**Re: Objection to Mirvac Projects Pty Ltd ("Mircac") State Significant Development Application SSD7874**

**Property: Harbourside Shopping Centre, 2-10 Darling Drive, Darling Harbour, Sydney("Harbourside")**

**Council Area: City of Sydney**

Image 83 Images Above - View from 50 Murray St residences

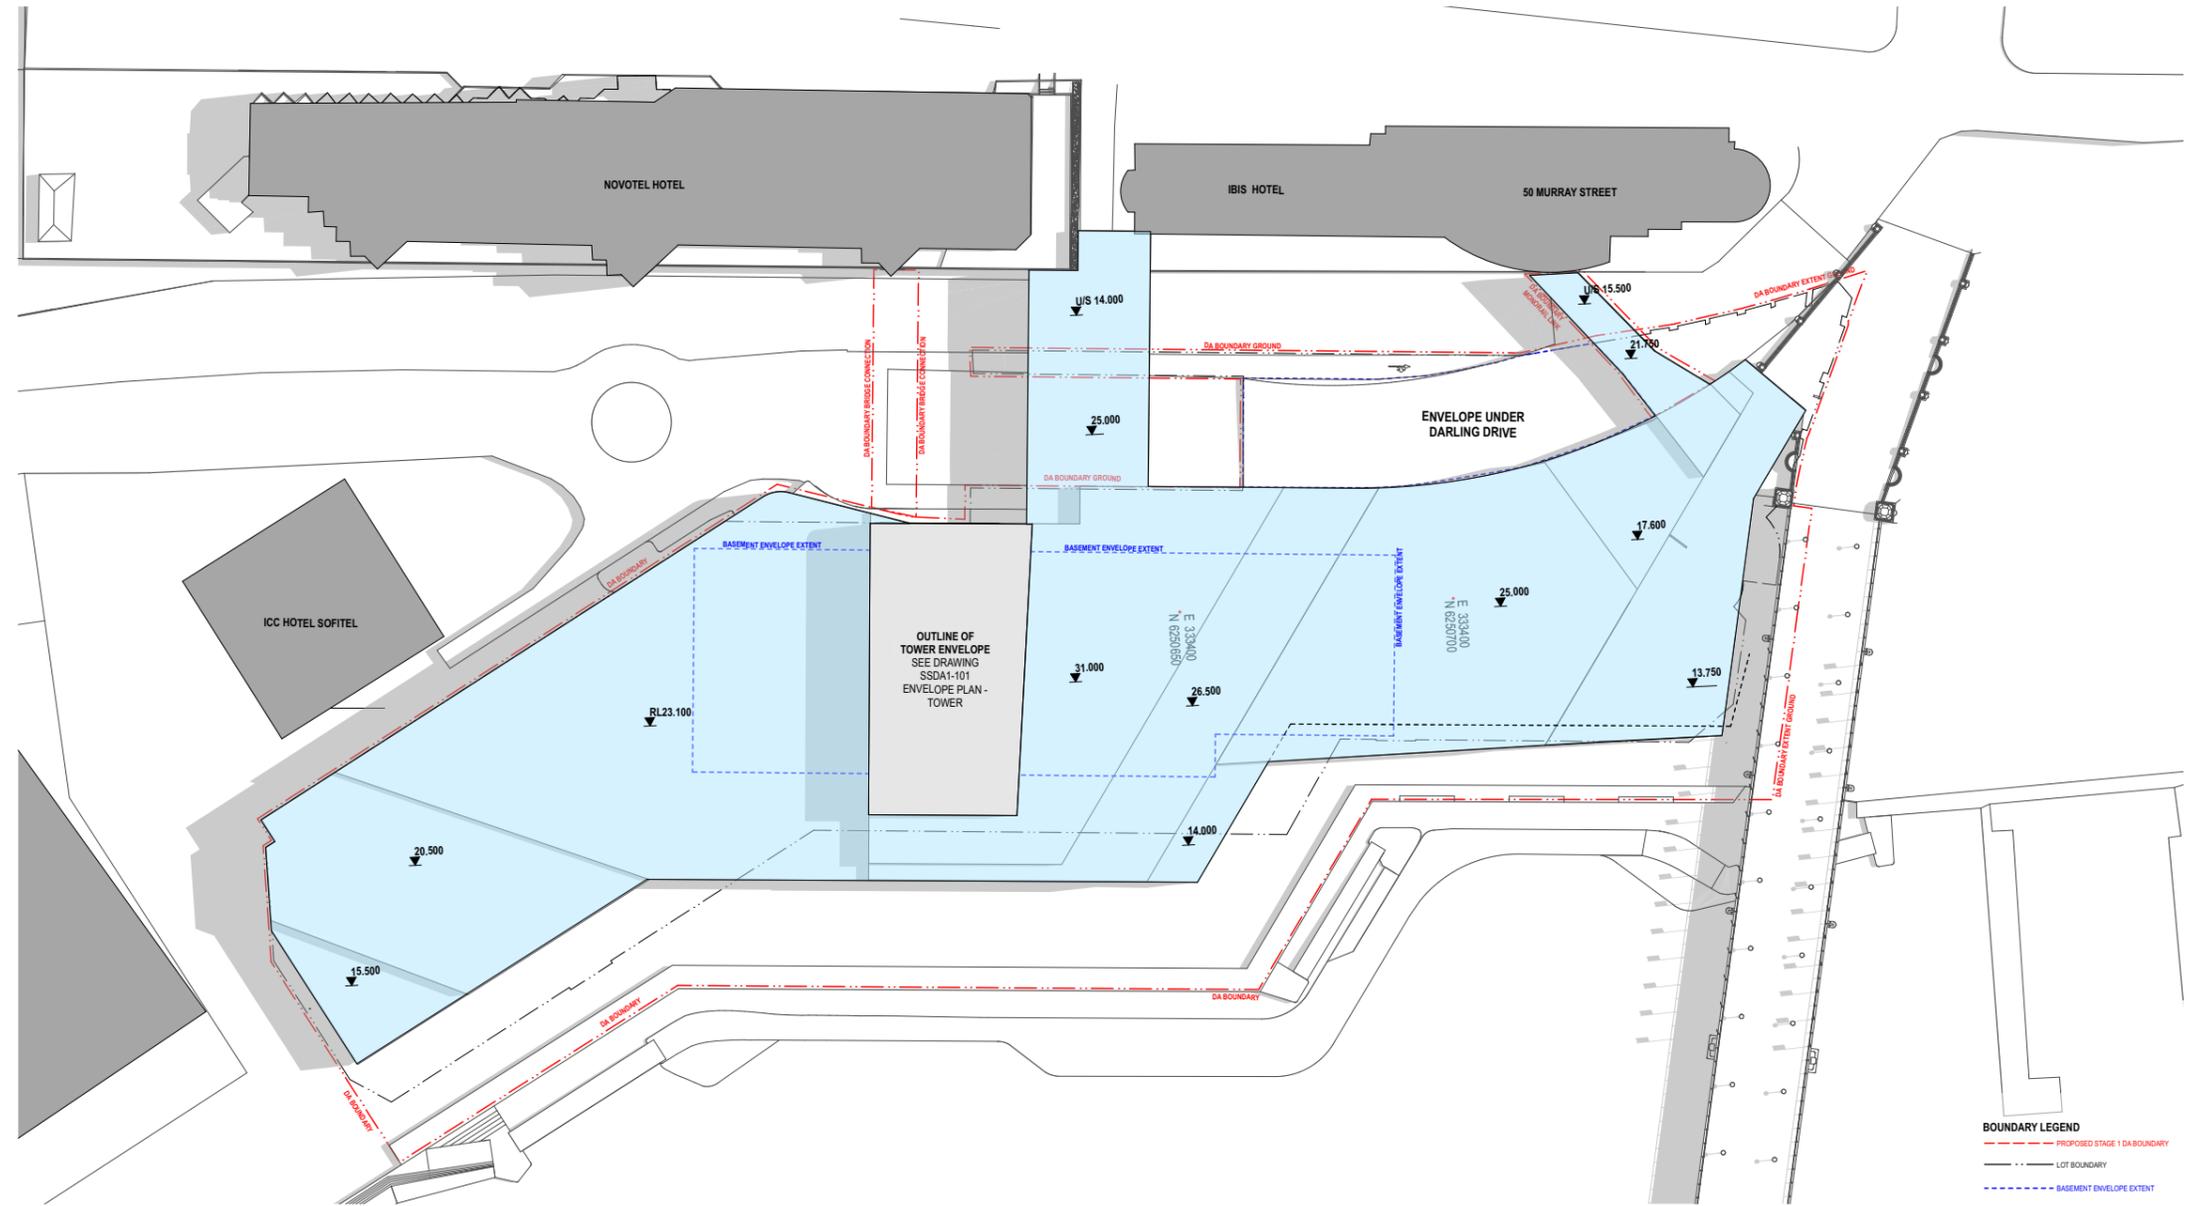
1. Our prime (and much prized) views would be wiped out by the proposed bulky and too tall podium and the too tall and too wide tower. Even if we retain some partial, disjointed views either side of the tower it wouldn't be the same as the expansive vista of the entire harbour we currently enjoy.

Mirvac has supplied a View Impact Analysis by JBA but has not "addressed" the issue of views lost by neighbours other than to identify that One Darling Harbour will be the neighbour most impacted by the proposed tall, bulky podium (twice the size of the current shopping centre) and 40 storey residential tower.

No attempt has really been made to accommodate reasonable view sharing. The tower is proposed to be simply plonked in front of One Darling Harbour thereby stealing its major views.

Mirvac's photographs in Appendix C which purport show the effect of the podium and tower on Apartment 1302 is indicative of how the proposed "slim" tower would obliterate my current 108 degree views to the East.

Somewhat self-servingly the JBA report suggests on page 29 the effect on Easterly and South Easterly views of the mid-rise and upper-level apartments of One Darling Harbour would be "minimal". I cannot agree. As someone who has paid a premium for my views, the effect would be devastating. The podium and tower would block the central portion of my current "whole" view of the waterways of Darling Harbour. Imagine for a moment
